KITITAS COUNTY

MEMORANDUM

TO: All Staff
FROM: Justin Turnbull, County Surveyor 
DATE: December 21, 2021
SUBJECT: County Survey Review of BL-21-00022 Pass Life Origins

| M.K.K./D.L.P. | 1" = 30' | 3 OF 5 |

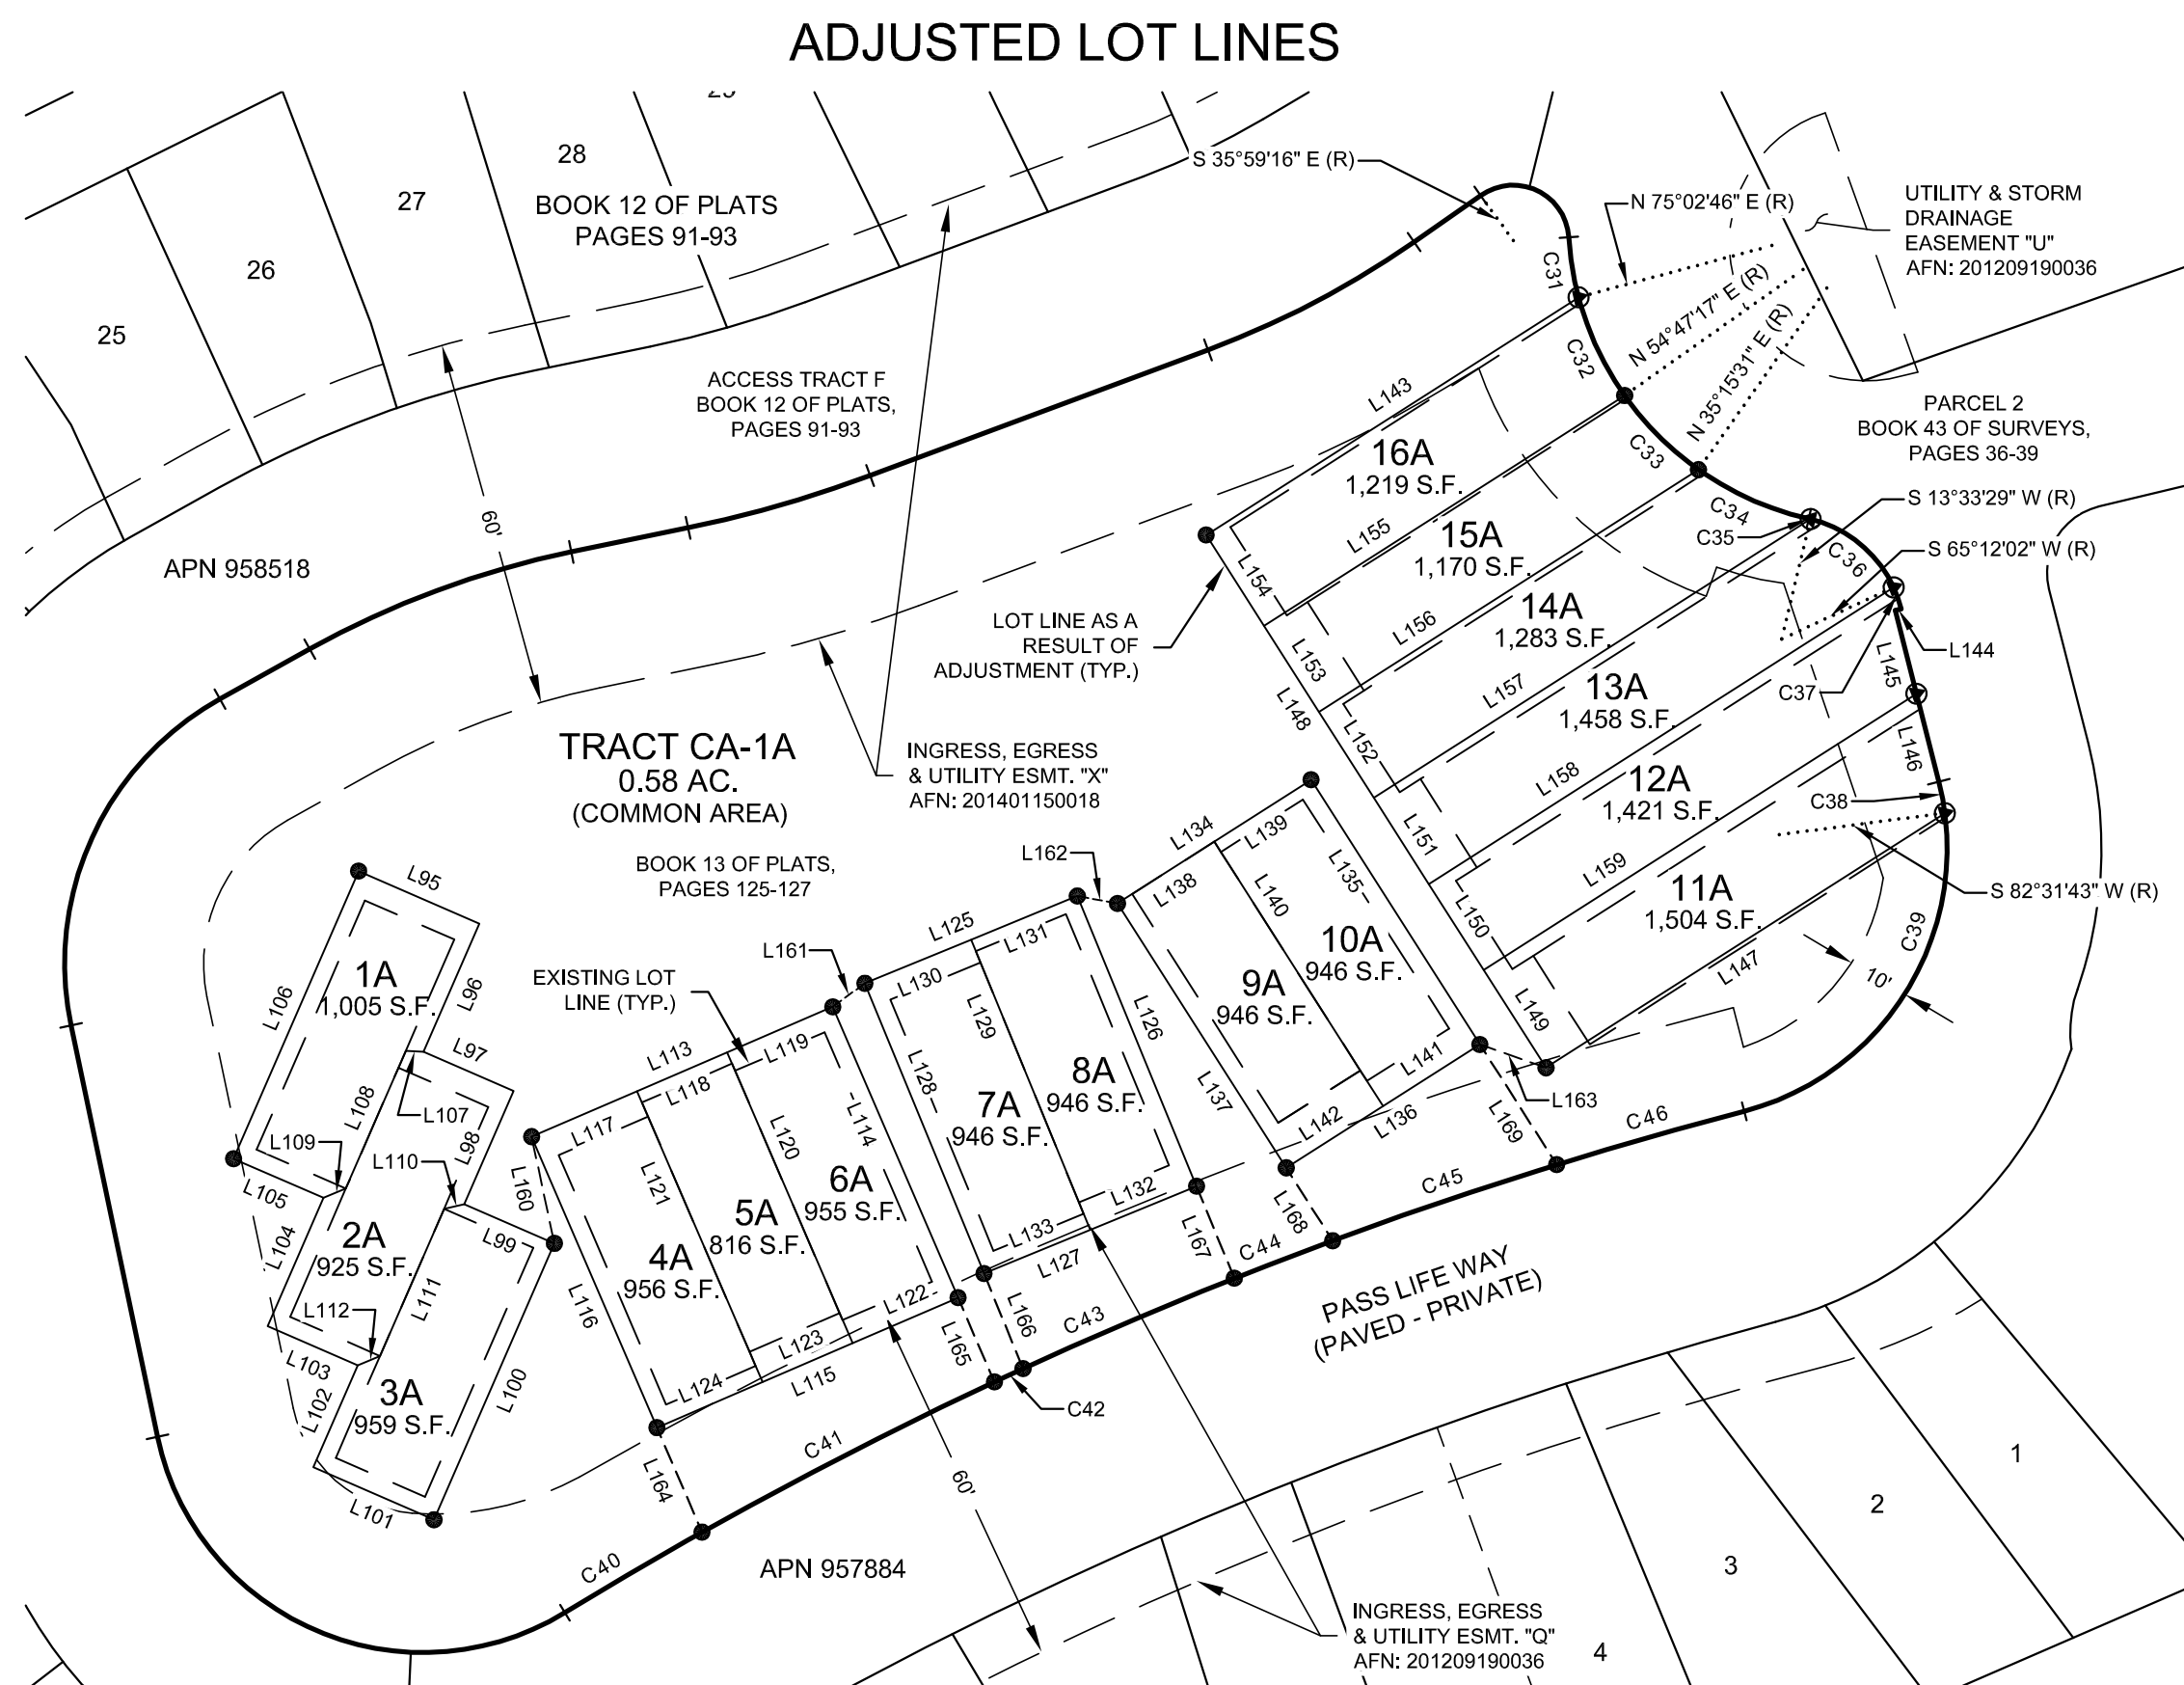
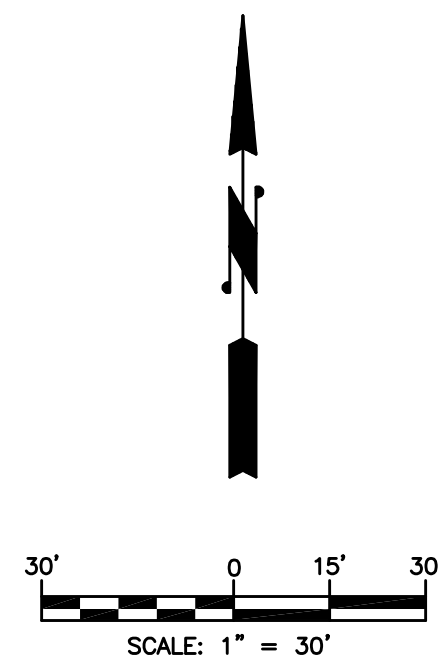
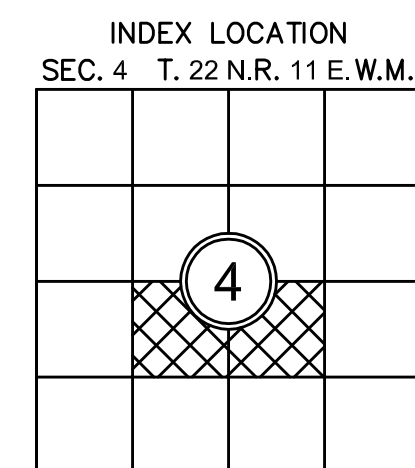
2. Show or note survey control utilized to determine boundaries.
